Subject: Planning Application 202591149

The Yew Tree settlement is an historic site, with records dating back to the 1500's and evidence that this site has been inhabited since medieval times. The reason why people have lived here for so long is the views of the Holme valley and this view is part of the historic character of this settlement.

site plan as proposed  
Scale: 1:200

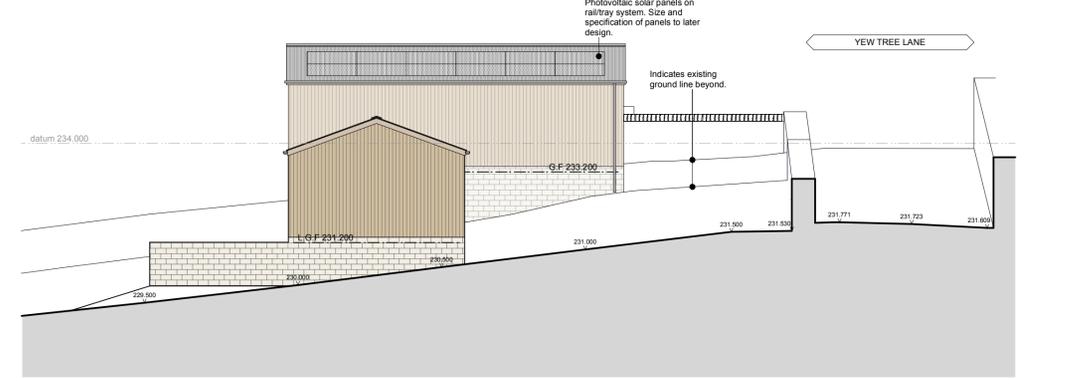
In the proposed plans there is the introduction of a stable block and an agricultural shed. This is a significant expansion of the current developed footprint of this site. These sheds will also block, obscure and change the views of the Holme valley from Yew Tree Lane, from the public footpath that runs through and the houses at the Yew Tree settlement. All of the new proposed footprint for stables and agricultural storage is currently in the building that is proposed to be repurposed as a domestic dwelling.

The development of the barn as a dwelling may be helpful in preserving the current agricultural building. The stables and sheds should be located to the rear of the proposed domestic development to protect the view for the public and residents of the Yew Tree settlement.

3) The planned development of additional stables and agricultural buildings will impact negatively on the view from and character of Yew Tree settlement. The chosen location could be located at the back of the proposed barn conversion as a compromise.
